Development Facilitation Team (DFT) – Review Comments

Project No: PR-2022-007103 Date: 07/10/2024 Agenda Item: #1 Zone Atlas Page: M-14

Request: Final EPC sign-off for Love's Sunport development, Loves Travel Center

Application For: SI-2024-00922 – EPC FINAL SIGN-OFF

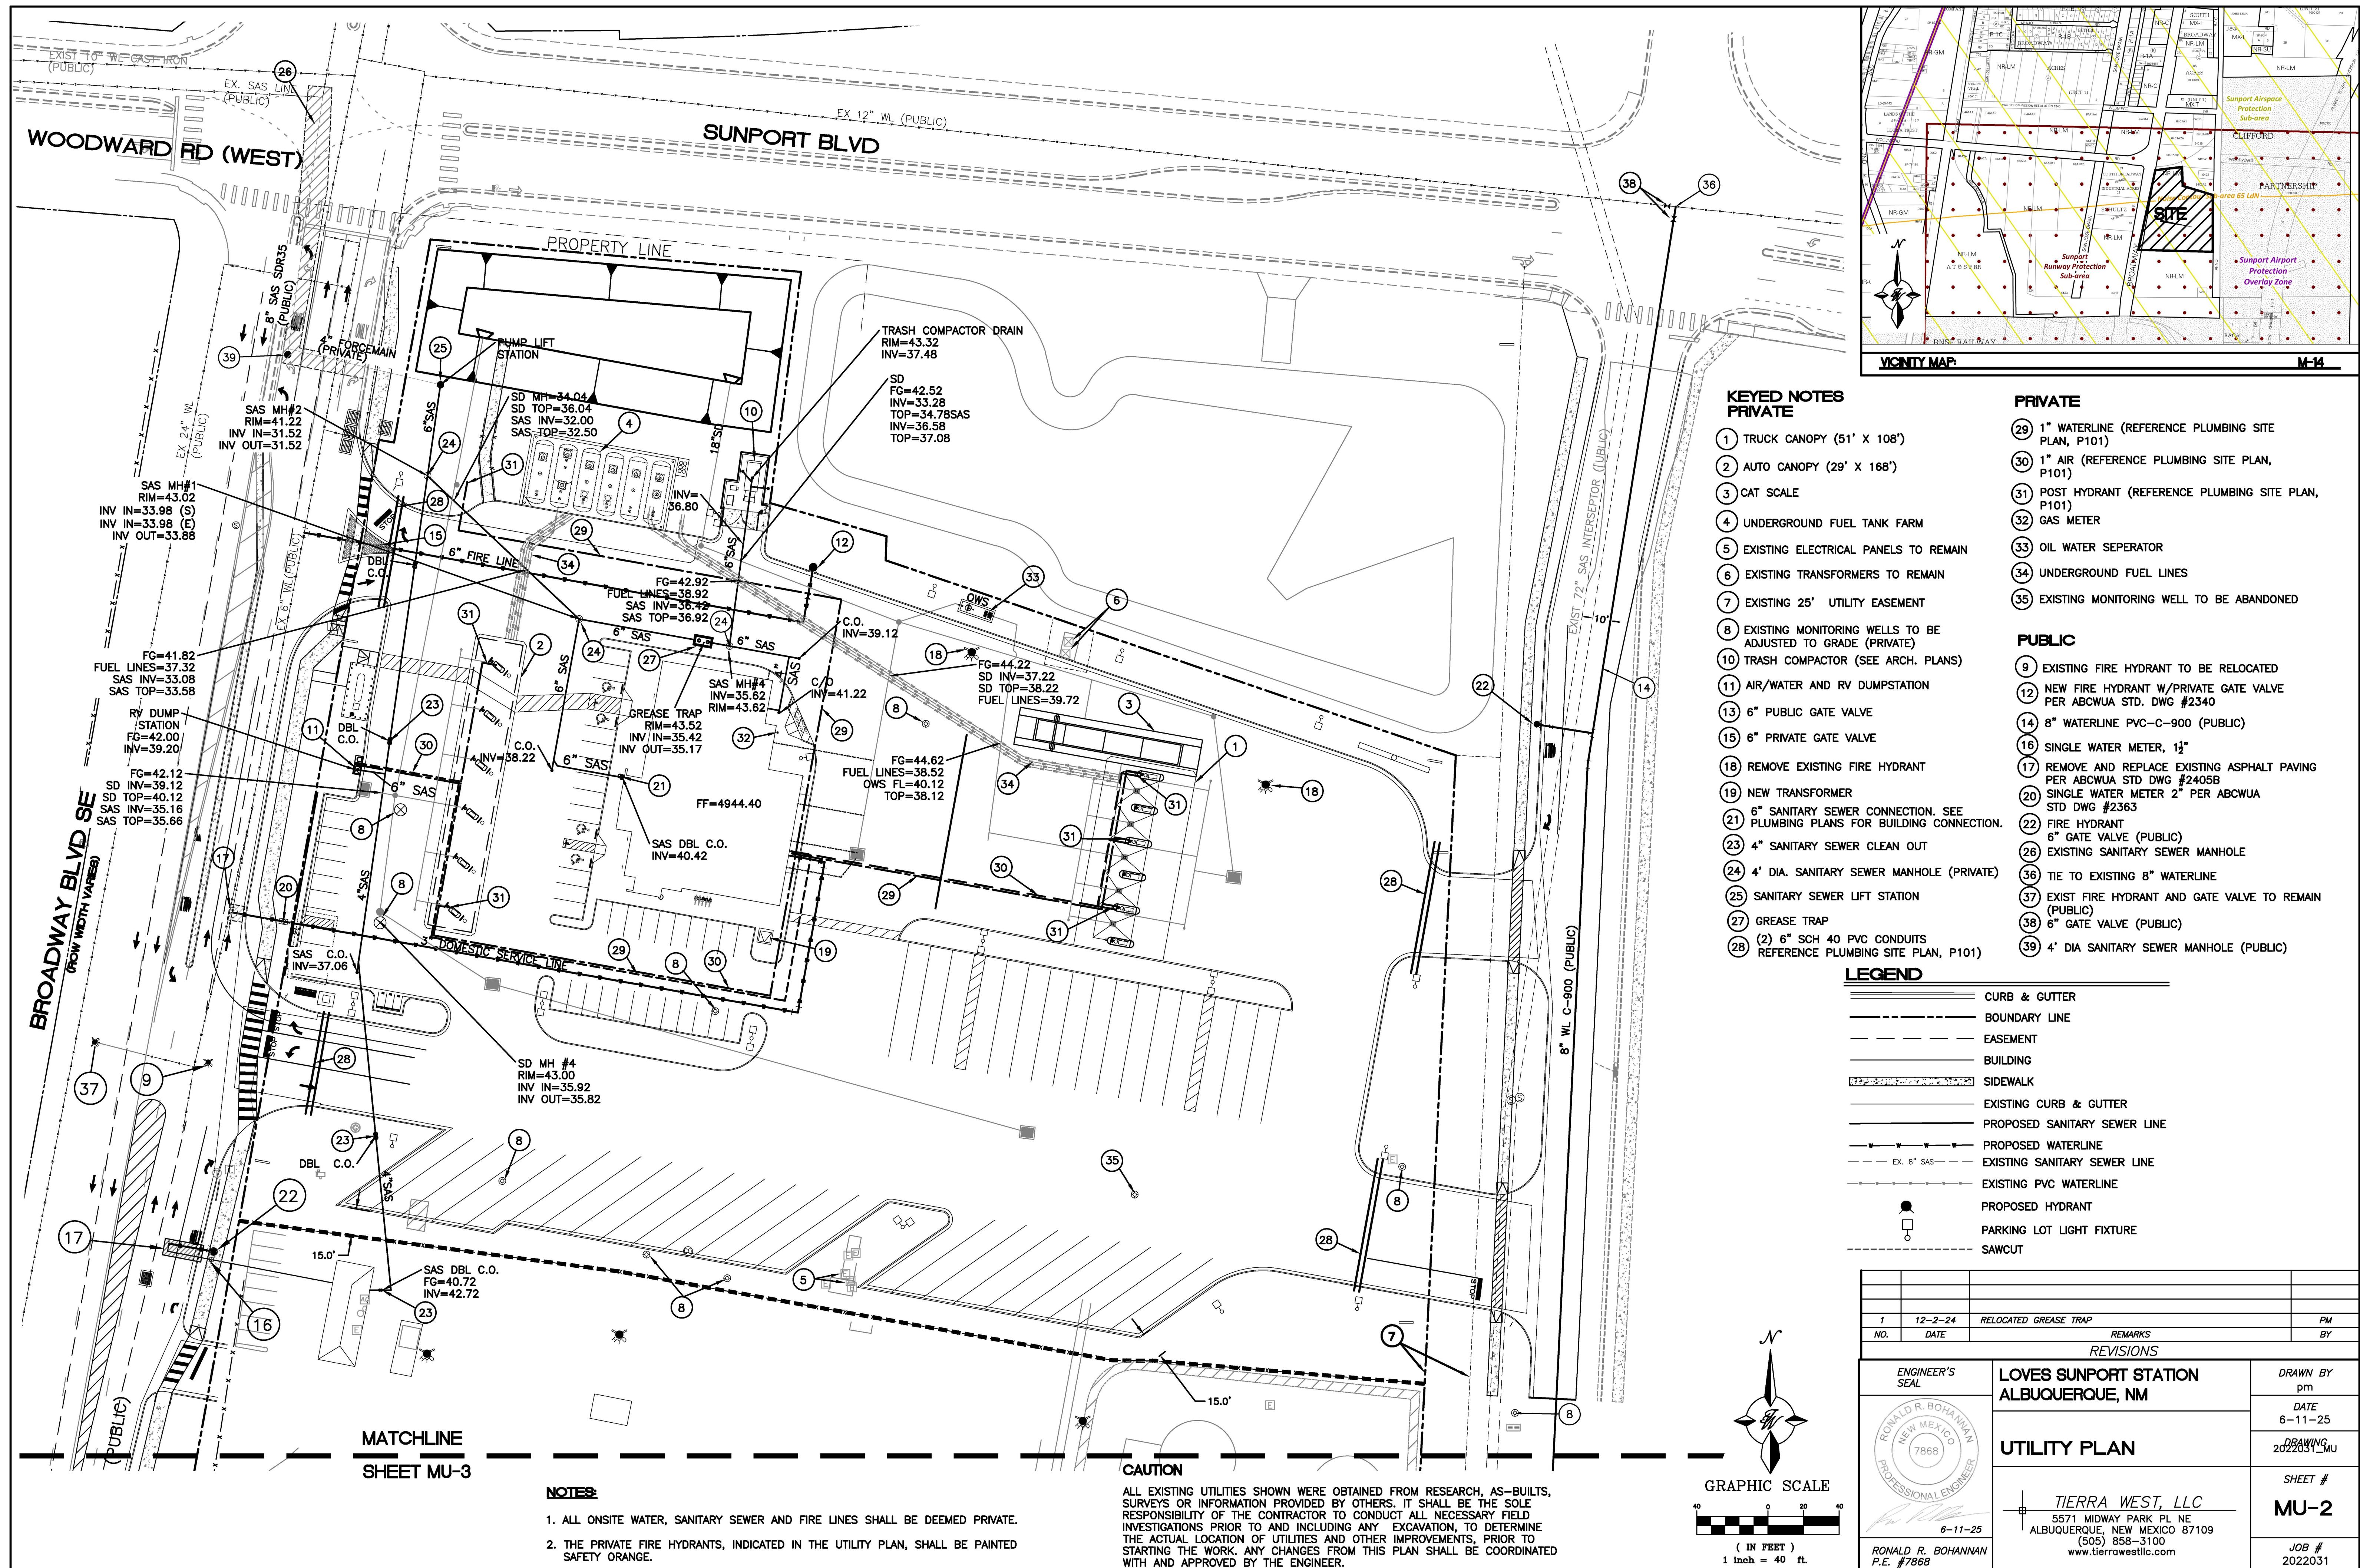
- b. Please note all necessary appurtenances shall be included (manholes, valves, fire hydrants etc...)
3. Utility Plan
 - a. Please clearly identify public vs. private infrastructure. **See Note 1 added**

- b. Please add the following notes to the Master Utility Plan **See Notes 3 & 4 added**
 - i. Coordination with Water Authority Cross Connection Section will be required to ensure proper backflow containment is in place prior to release of meter for the site. Contact the Cross Connection Section at 505-289-3454.

- ii. Coordination with the Water Authority Pre-Treatment Engineer is required to ensure the site complies with Water Authority Sewer Use Ordinance. Contact the Pre-Treatment Engineer at 505-289-3439.

- c. Coordinate with 811 to spot all existing infrastructure including Arno St. (there is an existing SAS interceptor along Arno) **done**
 - d. Please show existing easements if any exist as well as the existing sanitary sewer interceptor along Arno St. **no recorded easement found. Arno R.O.W. easement will be provided**

- e. Please note that the waterline must be 10 ft away from the existing SAS along Arno. This will be coordinated at the work order. (informational comment) **understood & will be reflected on DRC plans**
